City of Albuquerque Stormwater Construction Site Inspection Report

| Project Name: | Juan Tabo Hills Estates | | | | |
| Site Contact Name & Agency | Jeff Grady - Raylee jgrady@rayleehomes.com | ESC File No. | M21E018_R | | |
| Inspection Date: | 03/02/20 | Start/End Time: | 1145/1400 | | |

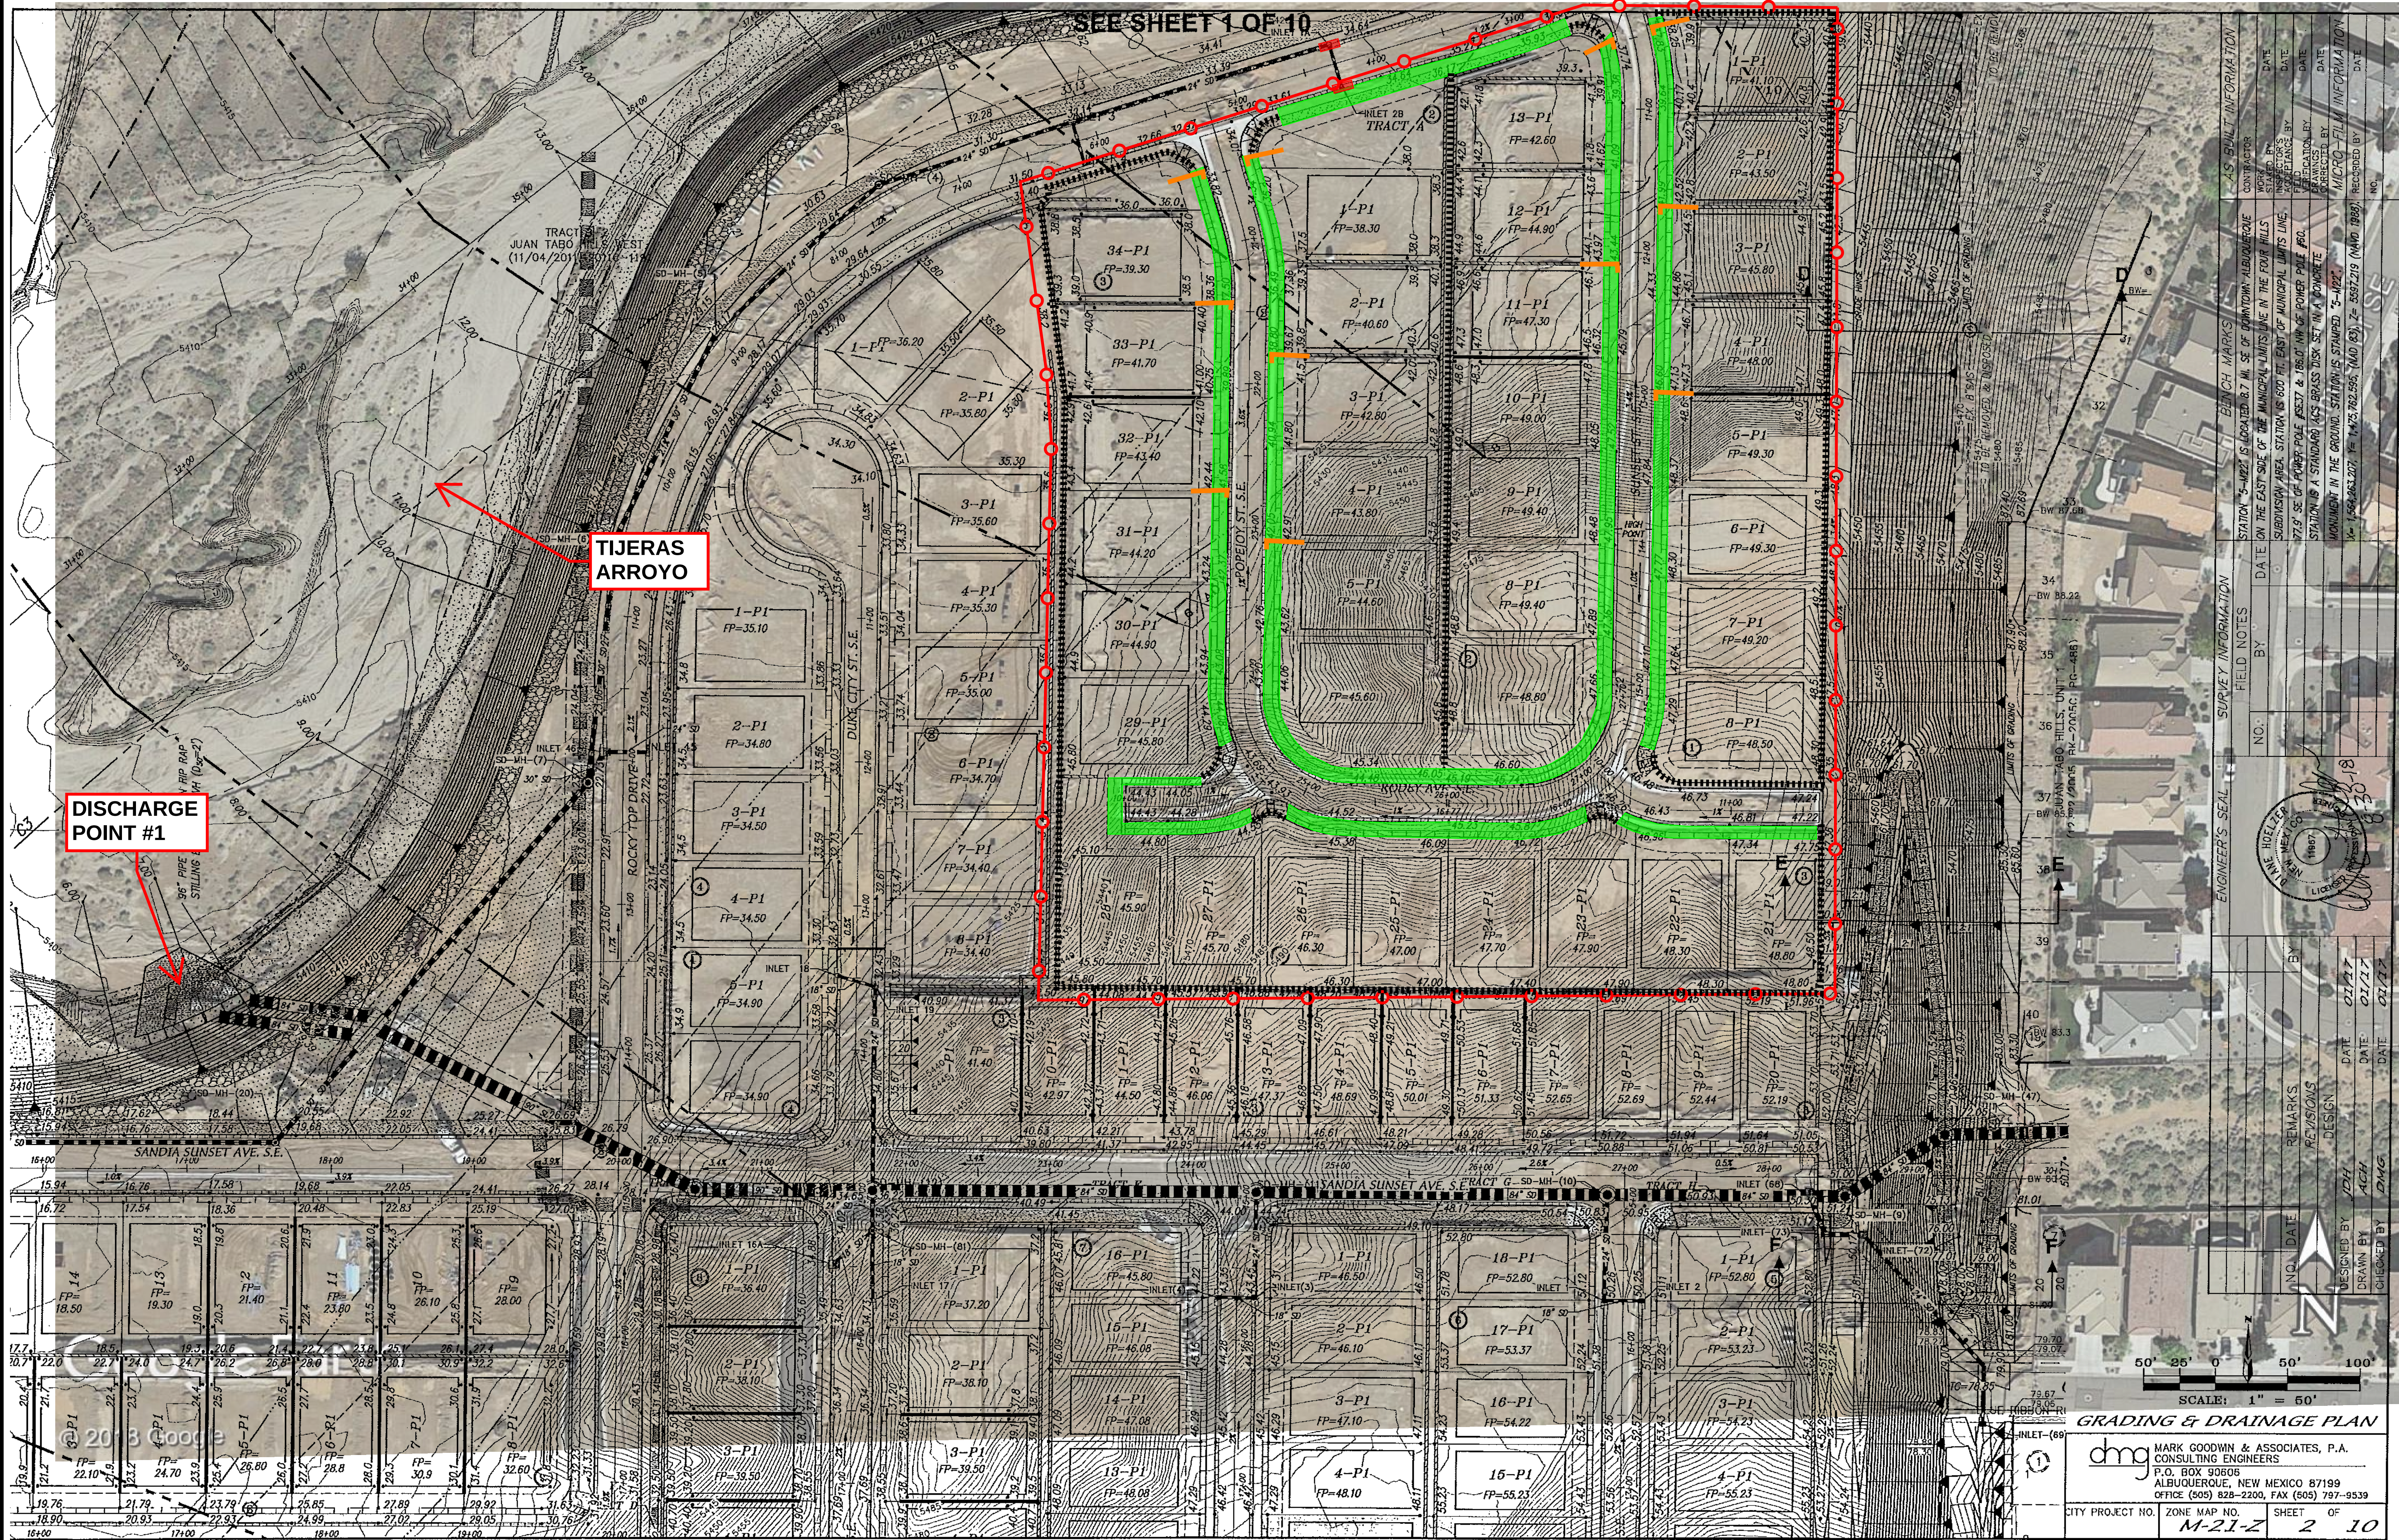
| Item Number | Deficiency/ Corrective Action | | |
|-------------|---|-----------|--------------------------------|
| 1 | Too much sediment is in the streets. Sweep and remove sediment. | | |
| 2 | Sheetrock in front yards, Please place all sheetrock remnants in approved waste container or utilize the gagrage in the interm. | | |
| 4 | Mitigate all washout from lots. | | |

| Notes: | noticed concrete washout facility requires maintenance. |
